MOUNTAIN VIEW ACADEMY - GRADING & EROSION CONTROL PLAN

Add PCD File Number: PPR-20-008

MOUNTAIN VIEW ACADEMY GRADING AND EROSION CONTROL PLAN COVER & NOTES

GEC-1

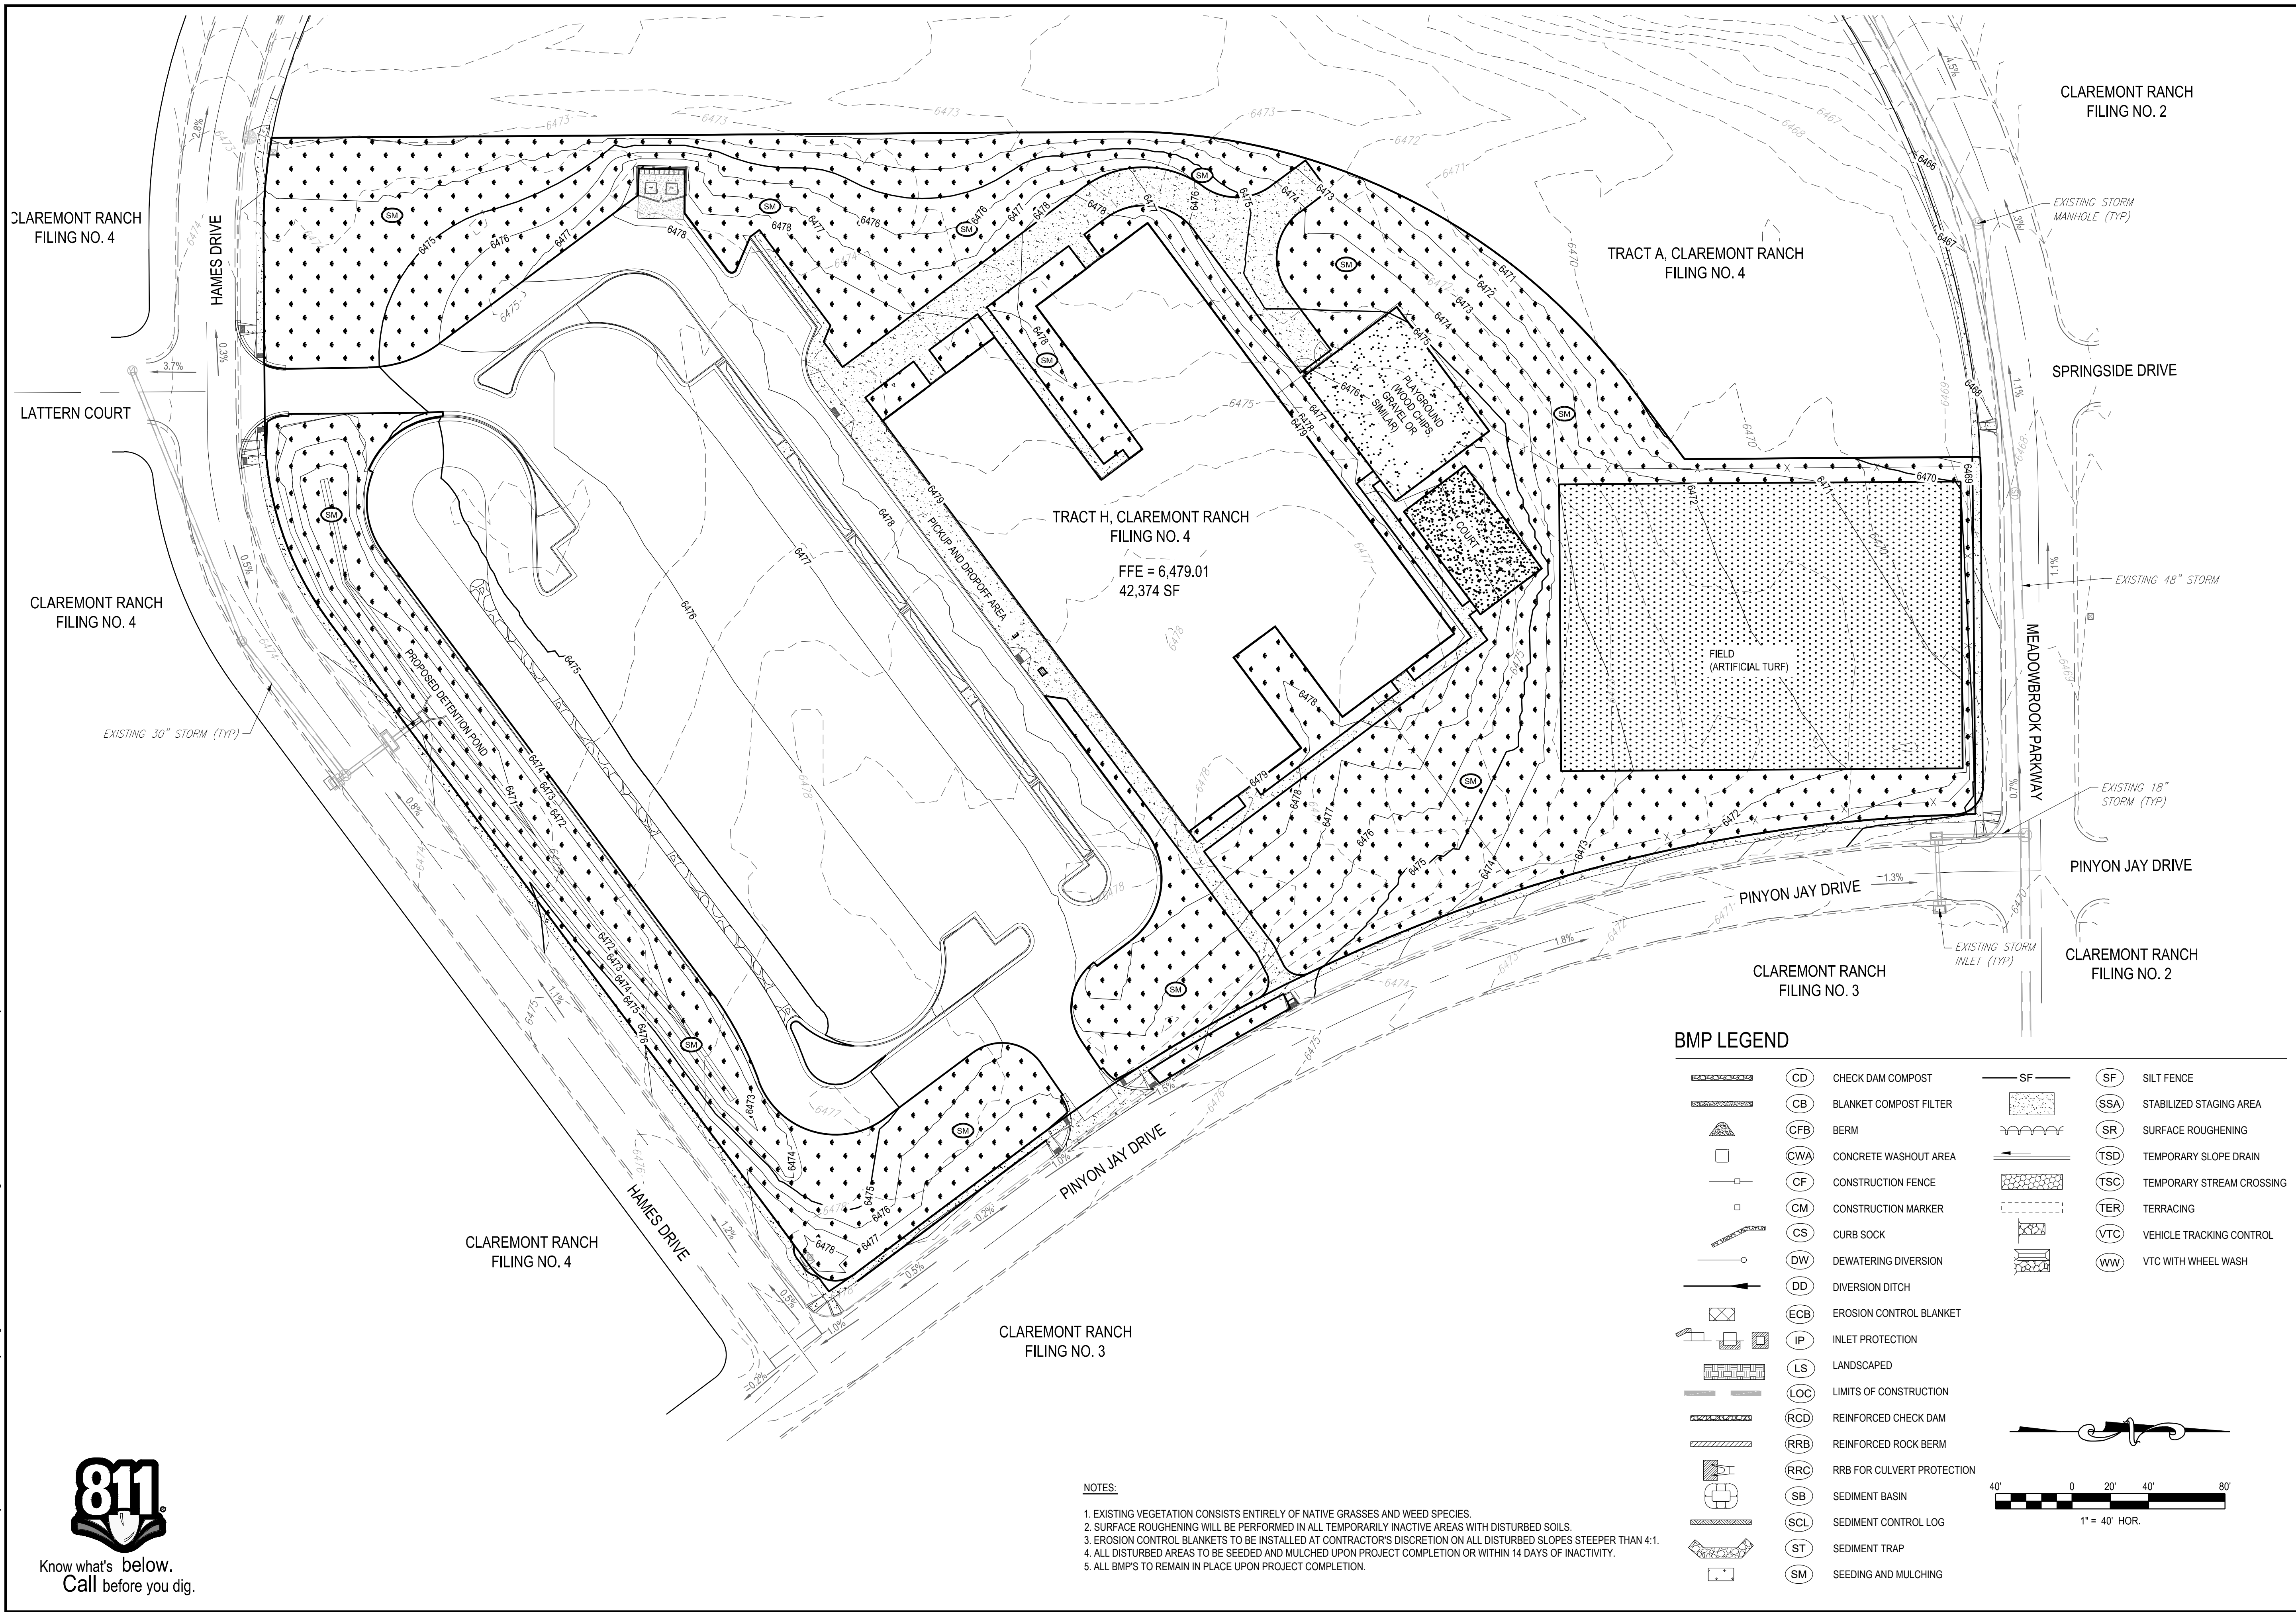
Update Legend to identify as both LOC and LOD if the delineation is the same for both

Remove BMPs that are not applicable to this site

Provide all BMP details

Show easements  
Show cut/fill areas  
Show stormwater flow lines
